City of Albuquerque Stormwater Construction Site Inspection Report

ESC File No.	B18E028	Project Name:	Burger King		
NPDES Id. No.	NMR100463	Location:	2110 Carlisle Blvd. NE		
2/28/2022	Owner	Contractor			
Operator	Auto Nation USA	Rycon Construction Inc			
Contact name & title	Fred Moss	Michael Burns			
e-mail	mossf@autonation.com	mburns@ryconinc.com			
Contact Phone #	954-769-2303	263-6965			
COA Inspector	Doug Hughes	Start/End Time:	4pm		
Construction Phase:	Excavation/grading				
Type of Inspection:	<input checked="" type="checkbox"/> Regular	<input type="checkbox"/> Storm Event	<input type="checkbox"/> Past Storm Event >0.25"	<input type="checkbox"/> 311/Complaint	<input type="checkbox"/> Follow Up
Weather at time of inspection?		clear		Temperature: ~	60
Estimated date of last storm 0.25" or greater		2/2/2022

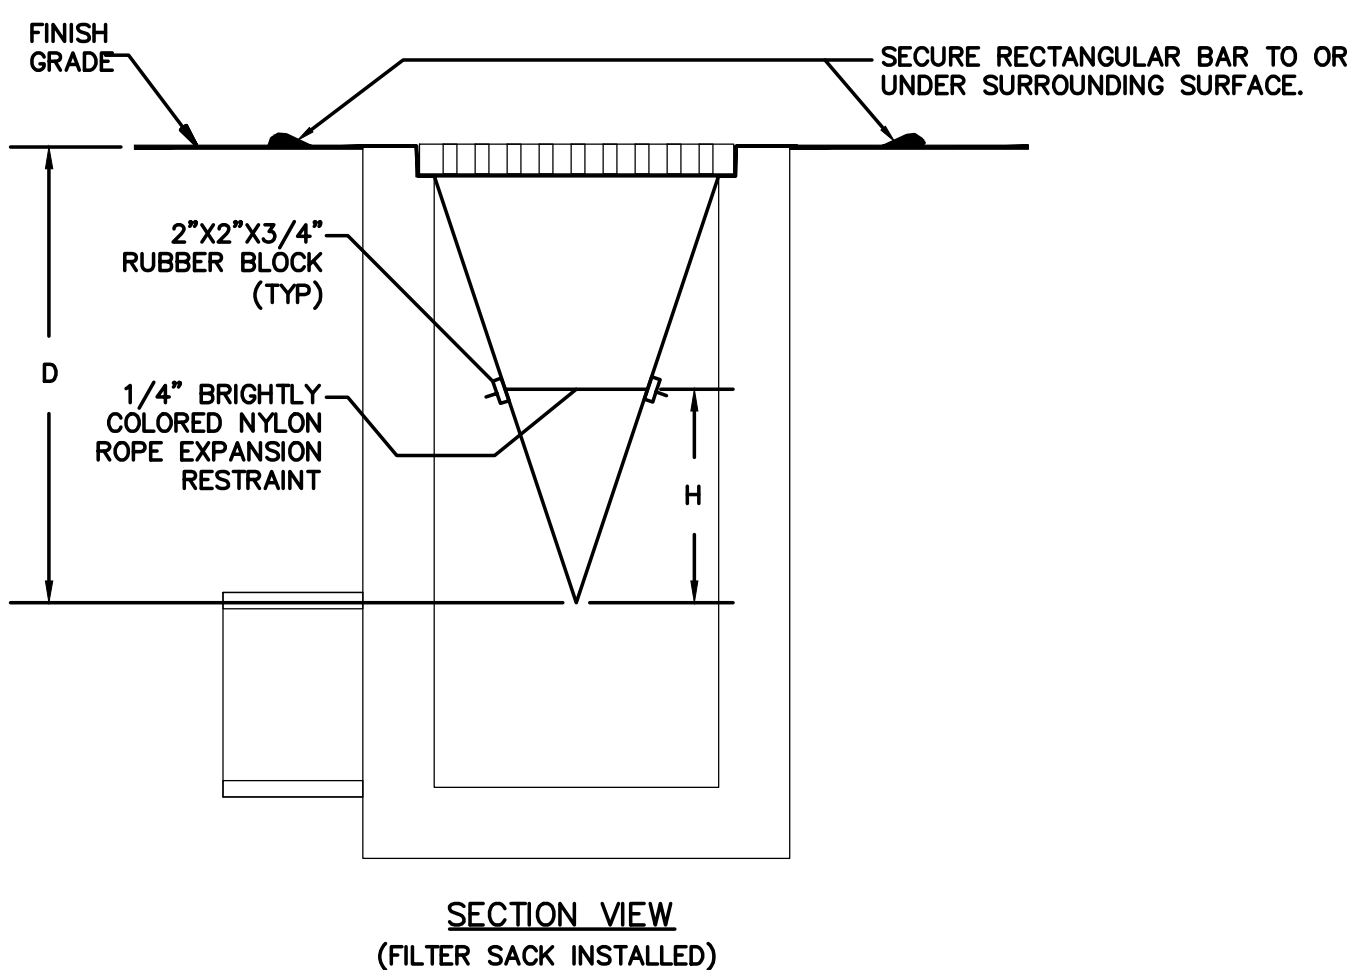
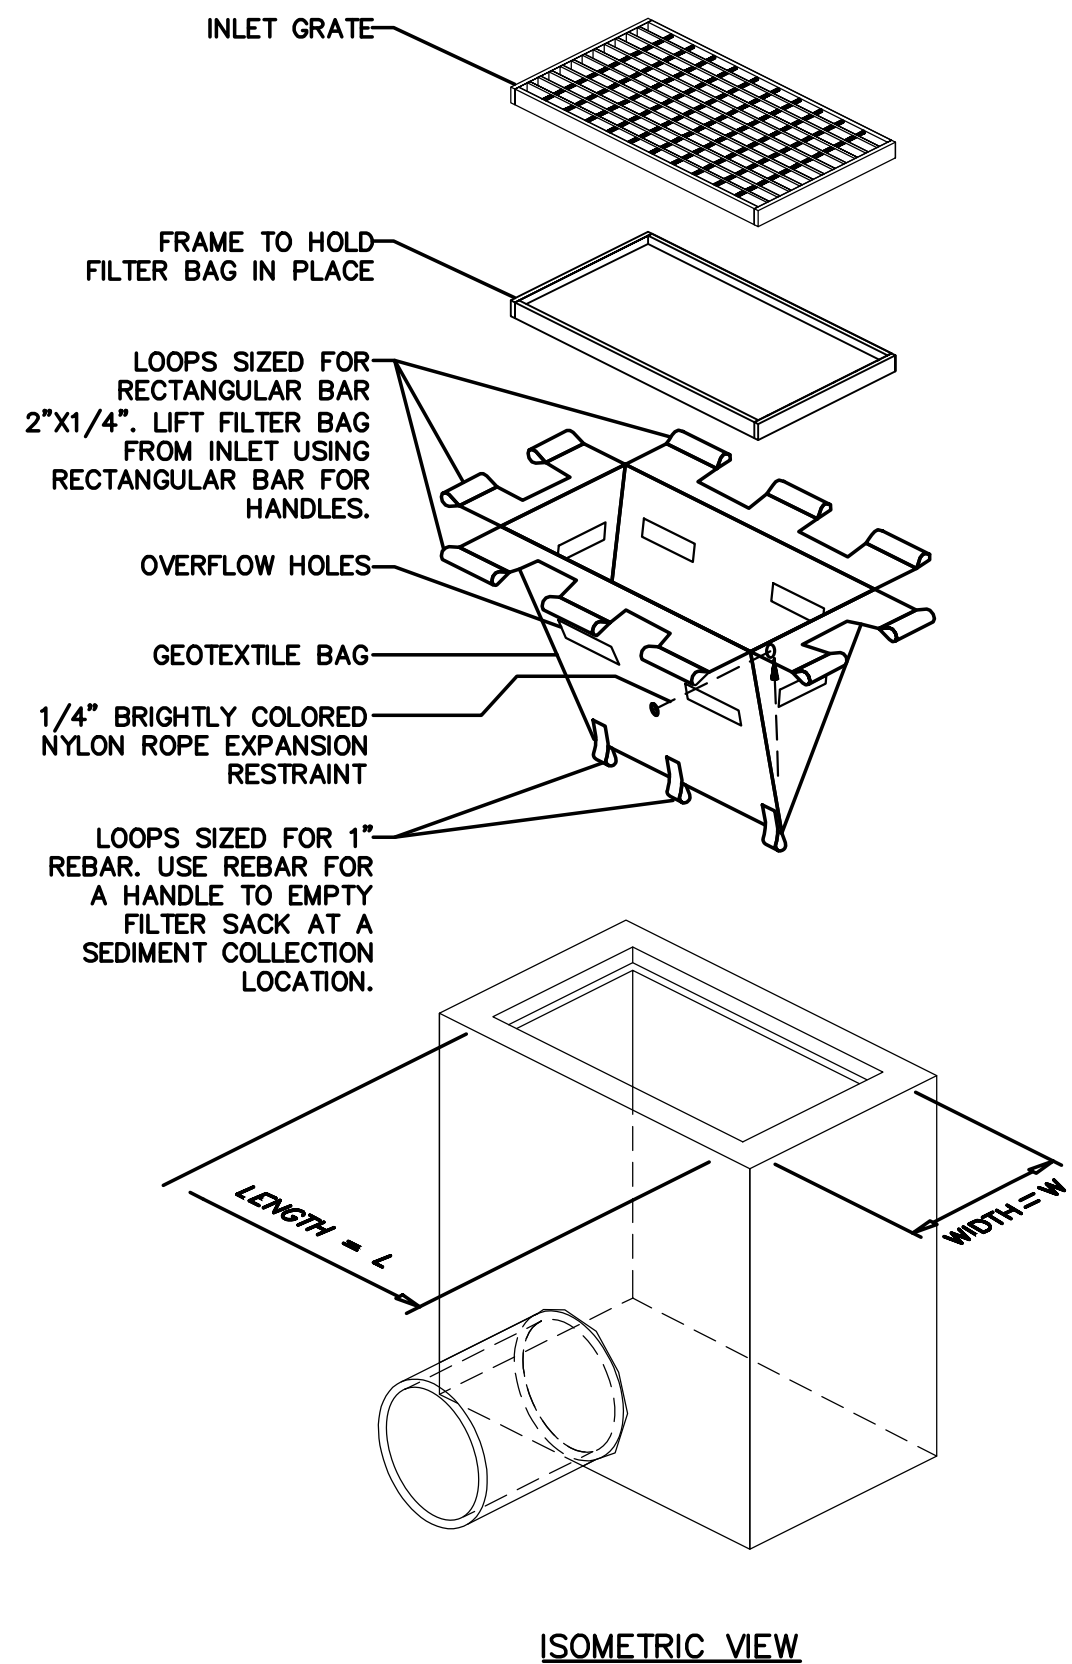
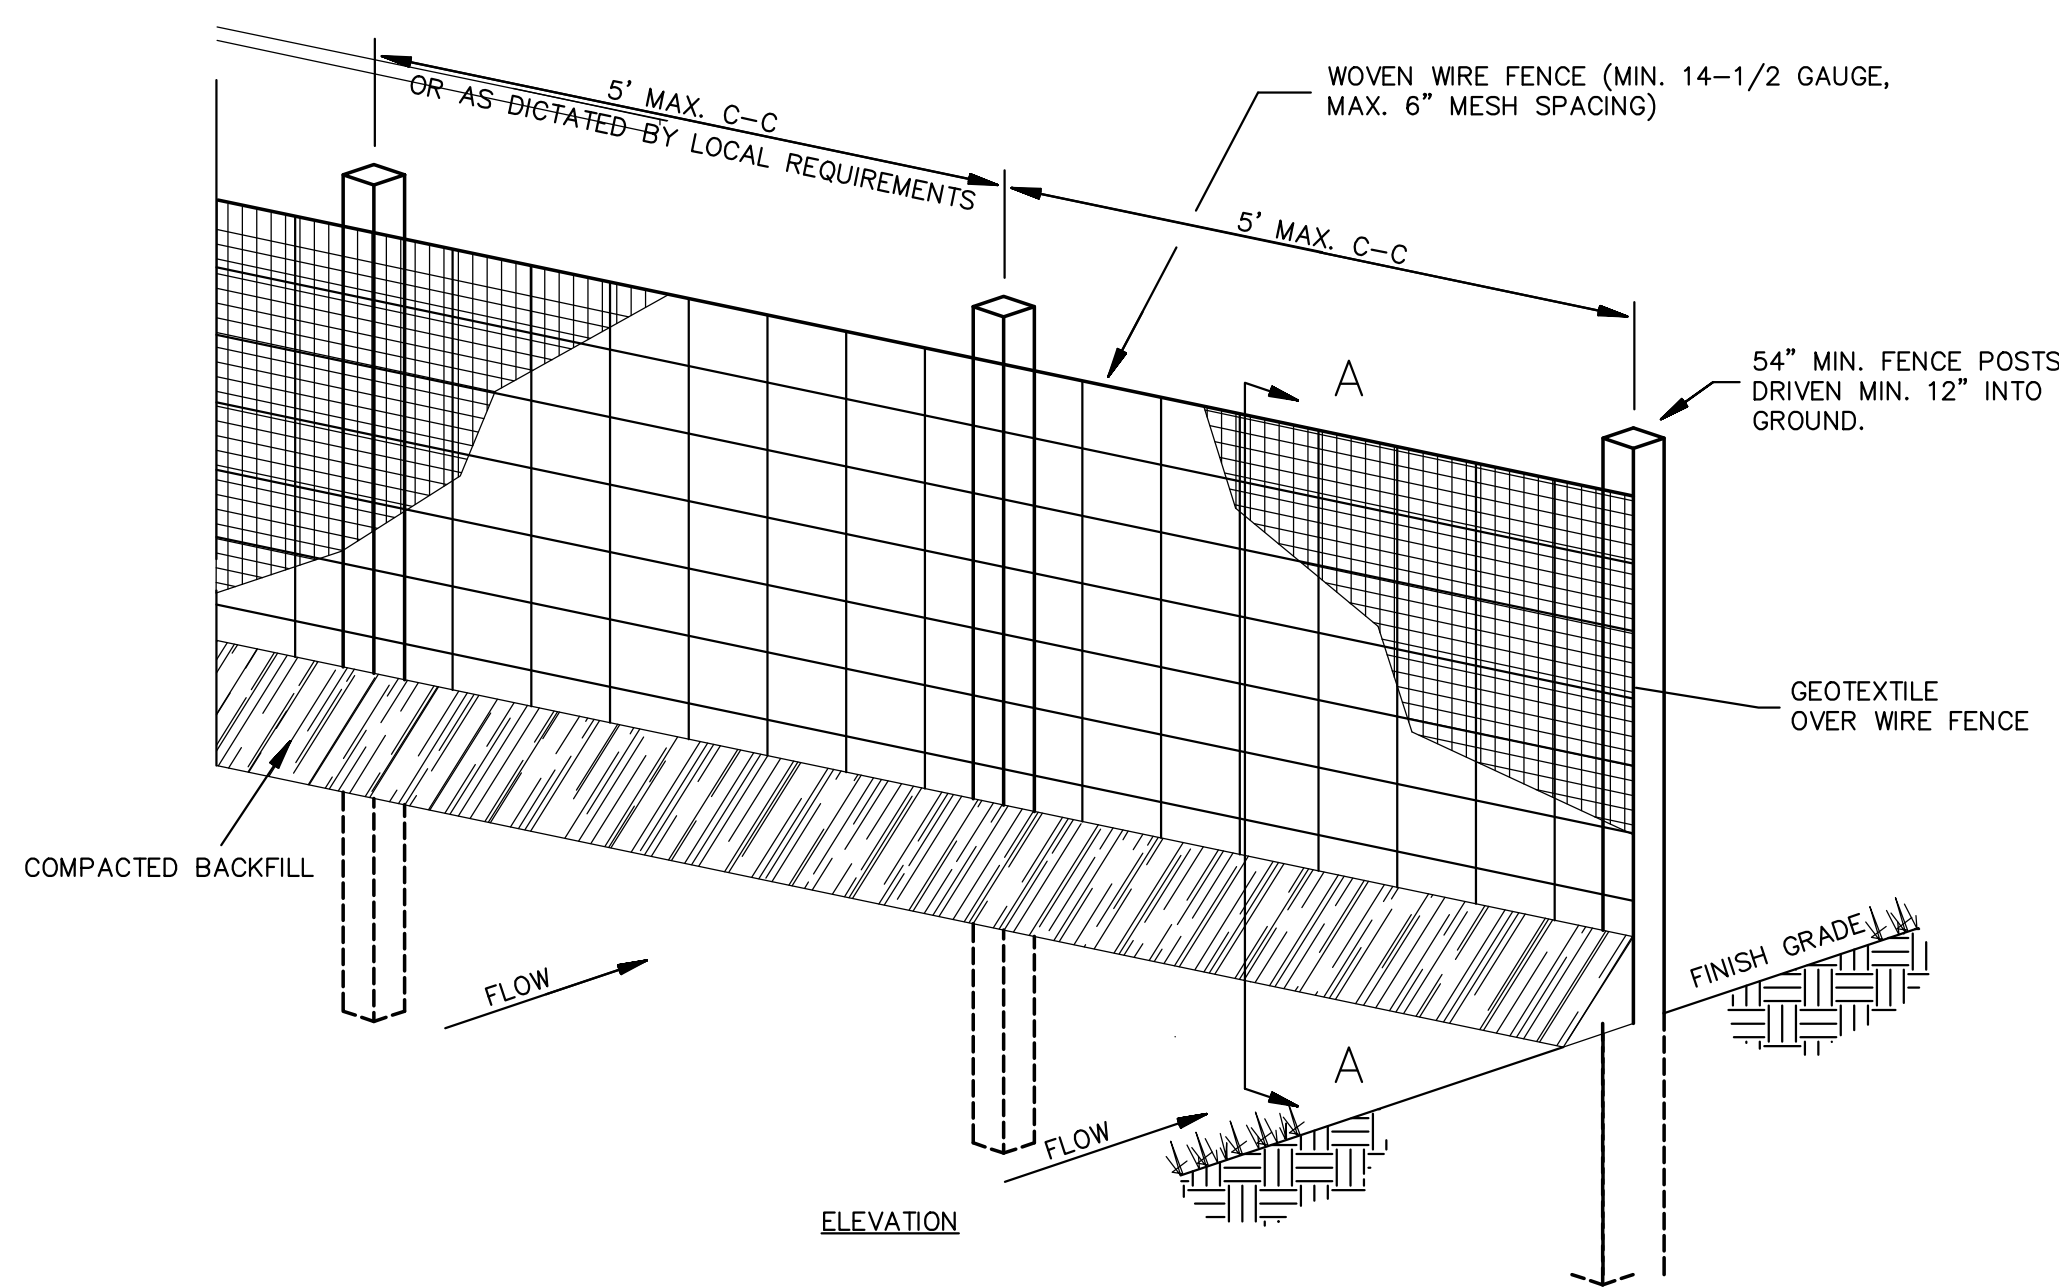
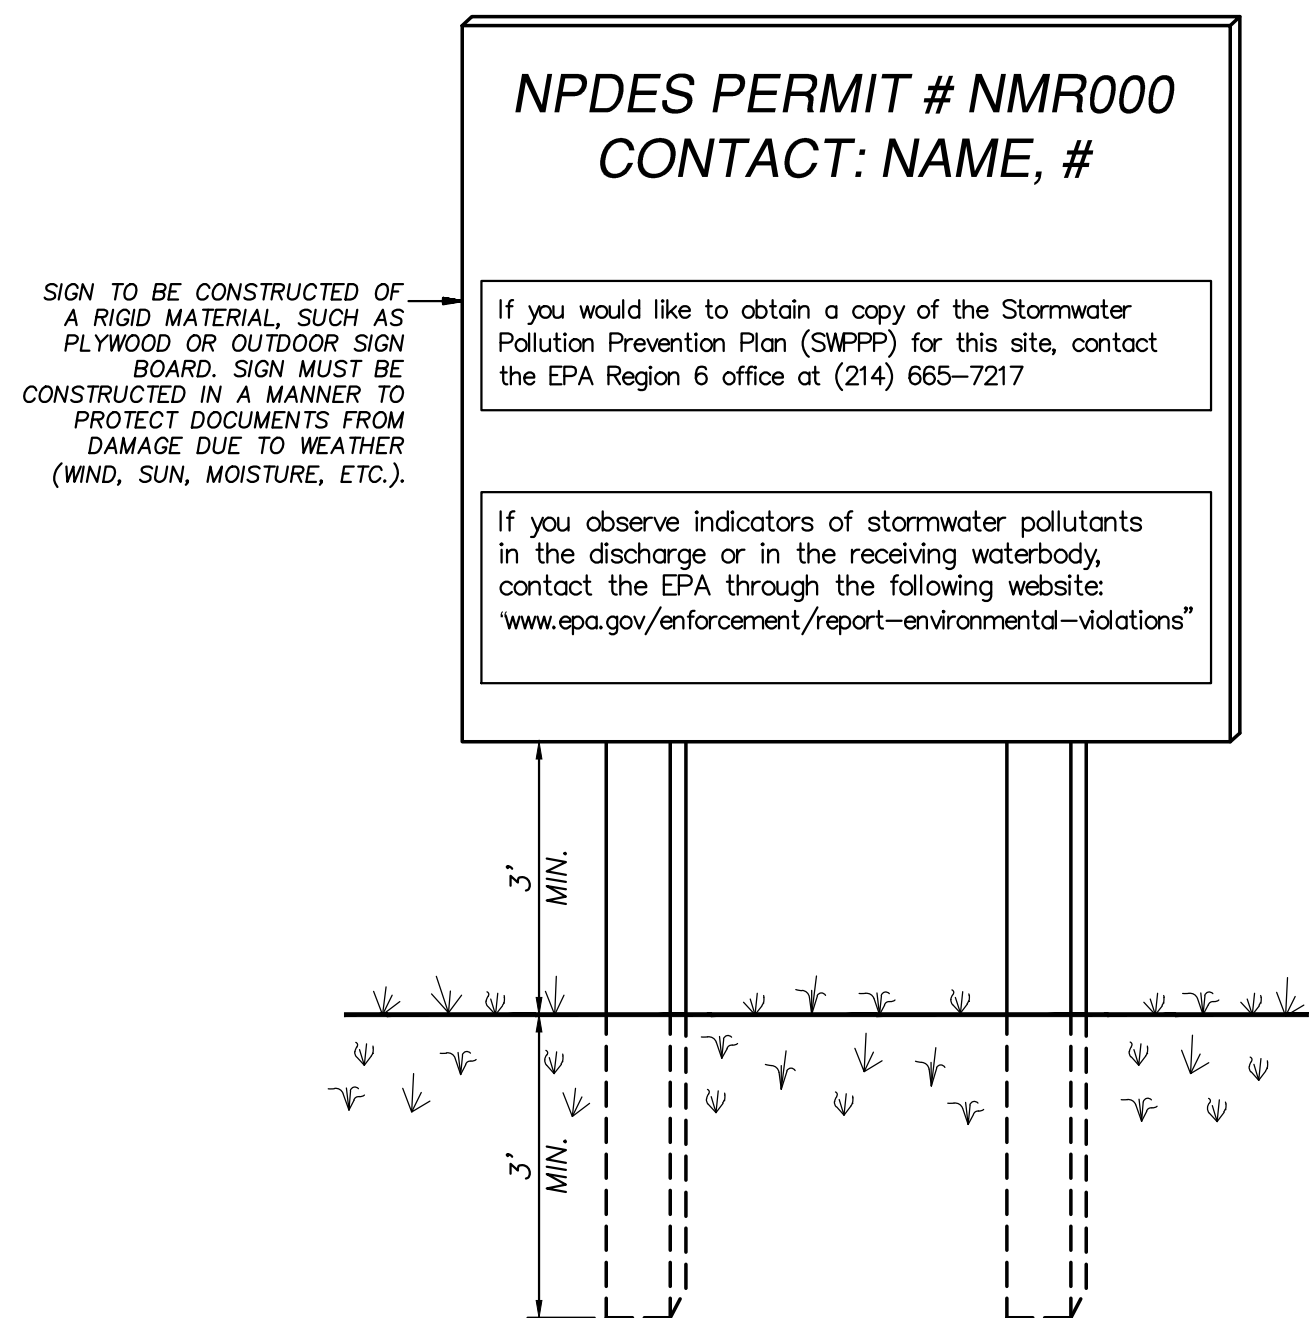
Notes:	
Foundation footings excavated and steel in the trench, but no washout container on site.	
The area of land disturbing activities has been increased to include the two lots adjacent to San Pedro, so the SWPPP map and NOI need to be revised, to update the SWPPP.
